September 4, 2014

**Subject: Convenience Store and Fuel Station Development – 2282 Congress Street**  
**Applicant: Portland Property Holdings, LLC**  
**Response to Ben Viola’s Review Comments Dated August 22, 2014**

Drawing file: Aug8_misnum sub / C-9.1A.pdf

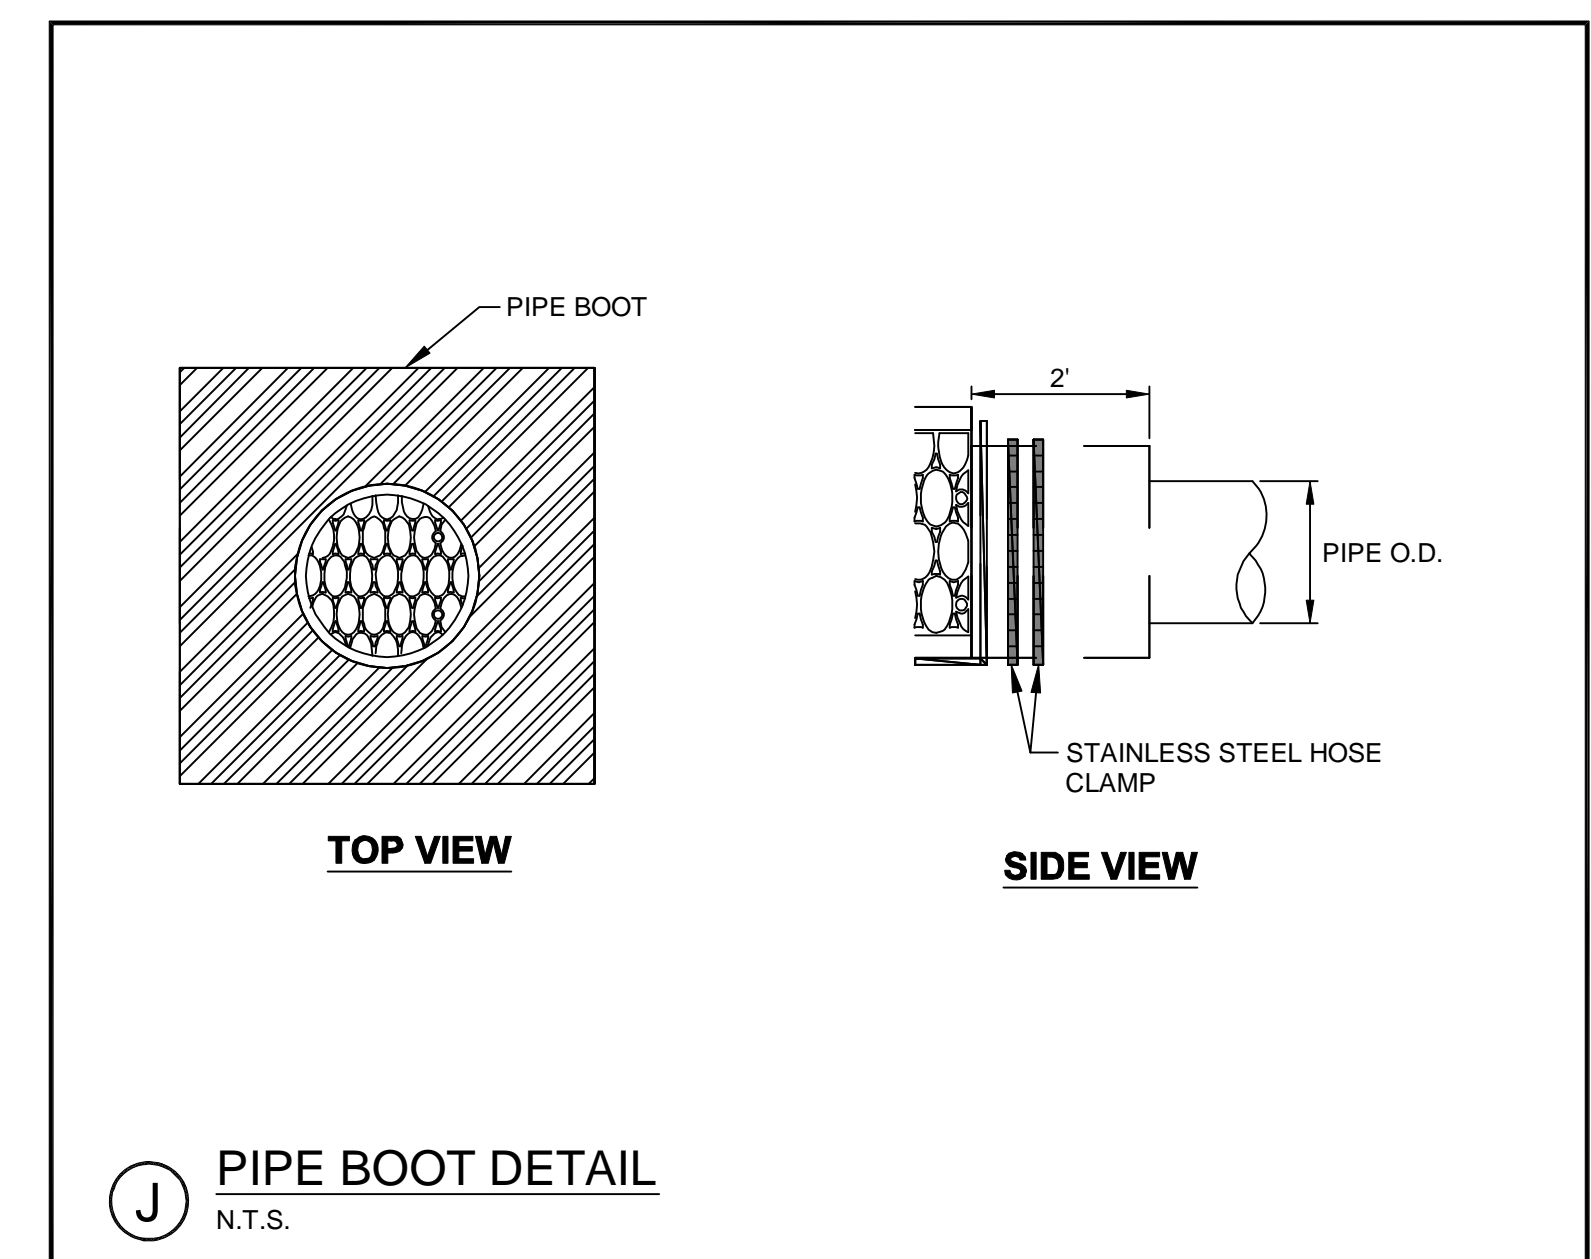
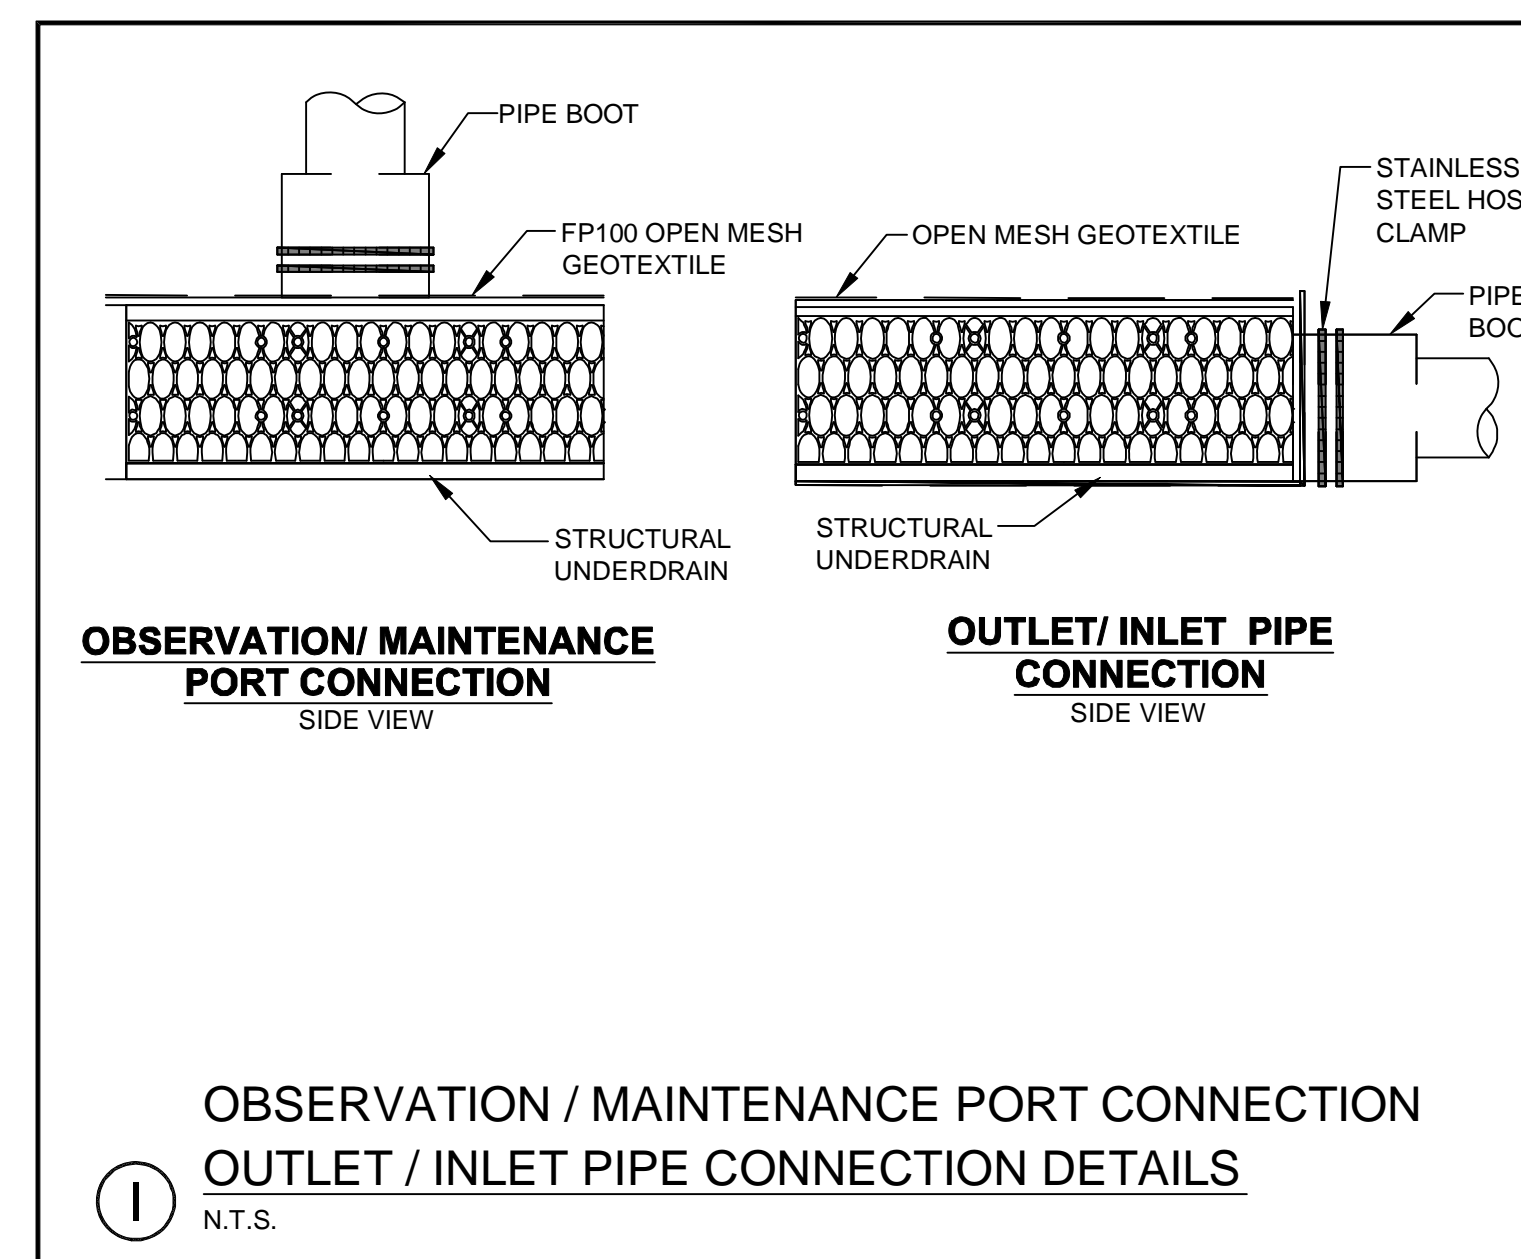
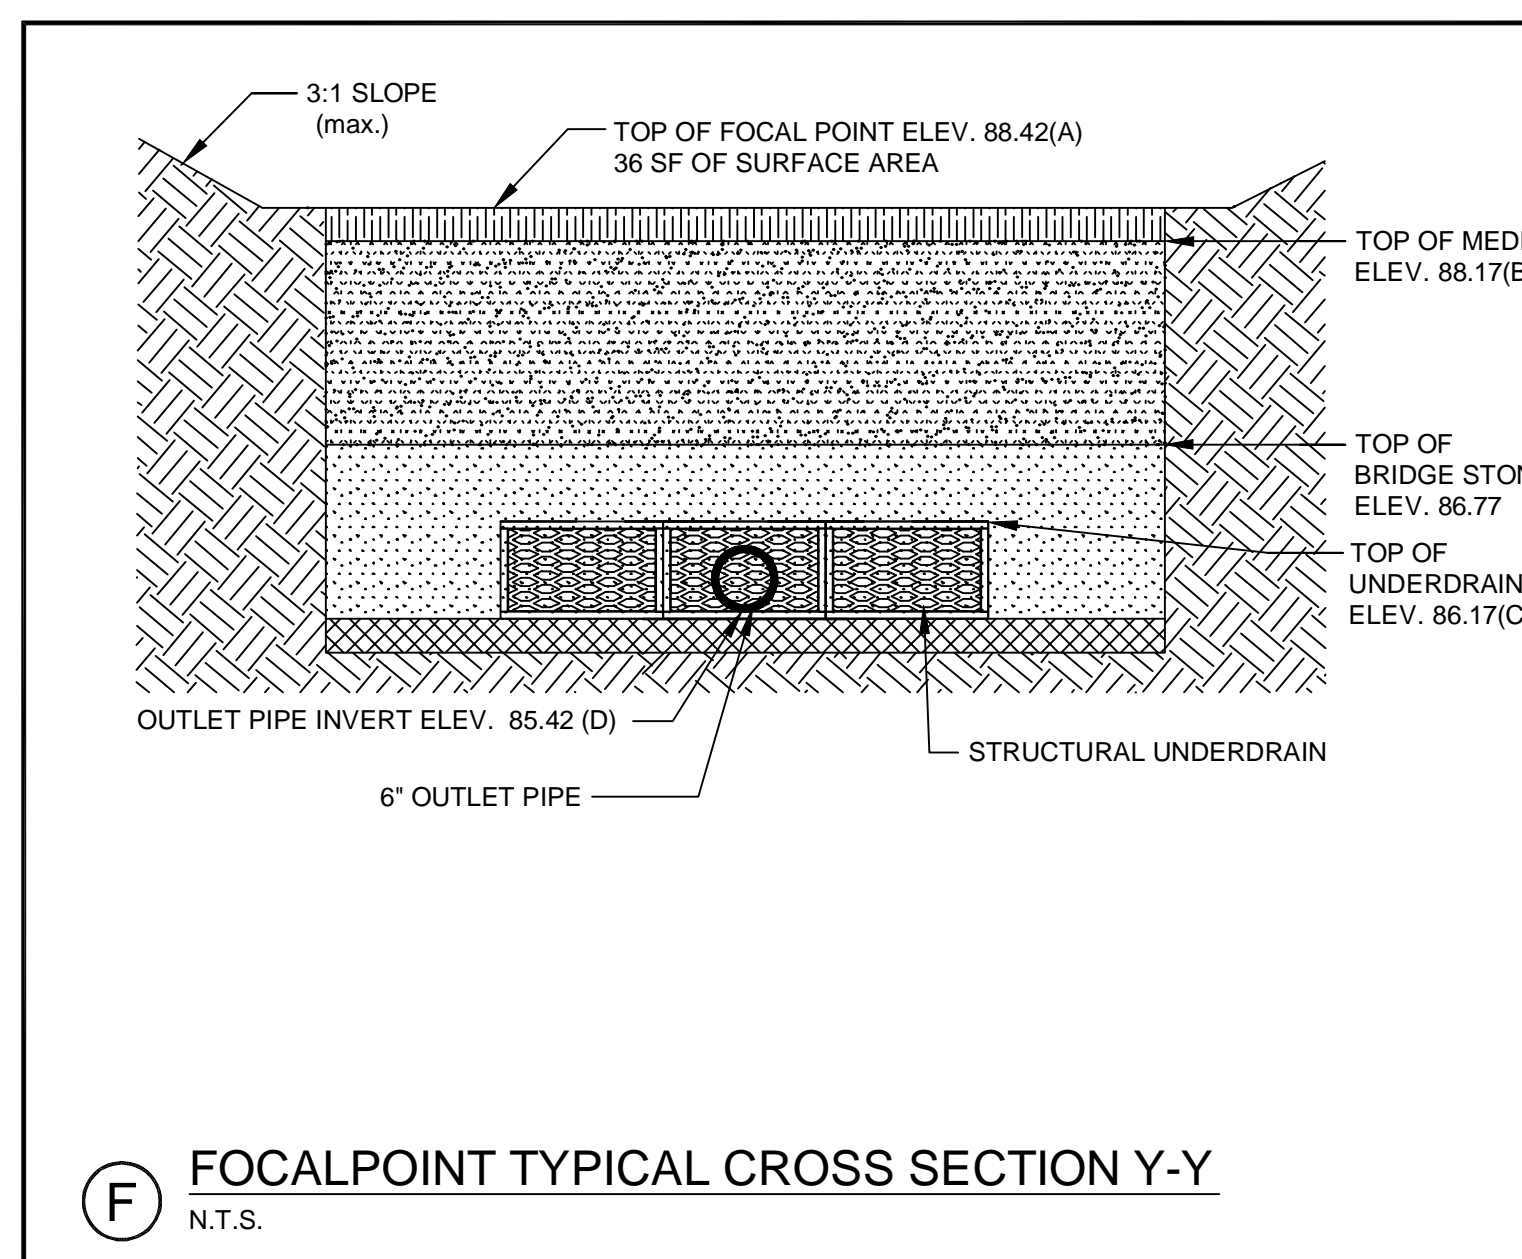
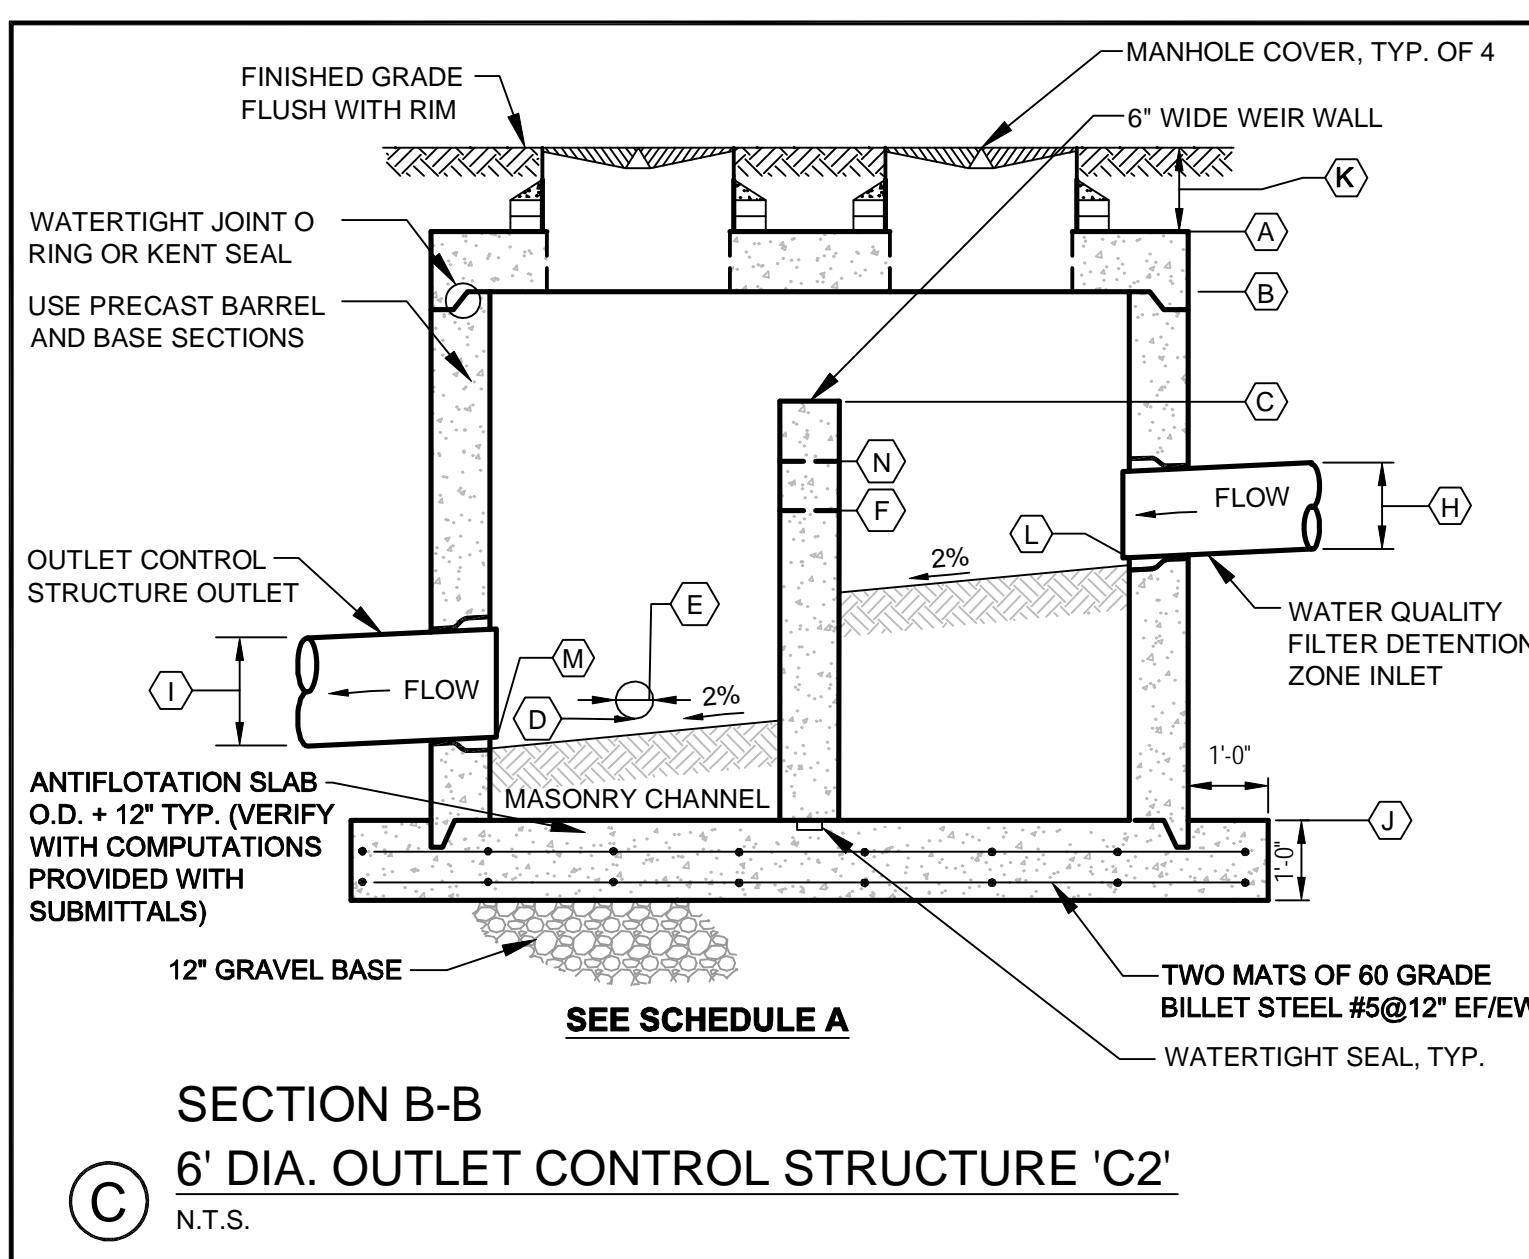
*Currently we are not approving the Focal Point in this type of application. Therefore this option must be removed from the plan set.*

Design Sheets C-9.0A and C-9.1A have been eliminated from the plan set. The project stormwater will be treated using a grassed underdrained soil filter as shown on Sheets C-9.0 and C-9.1
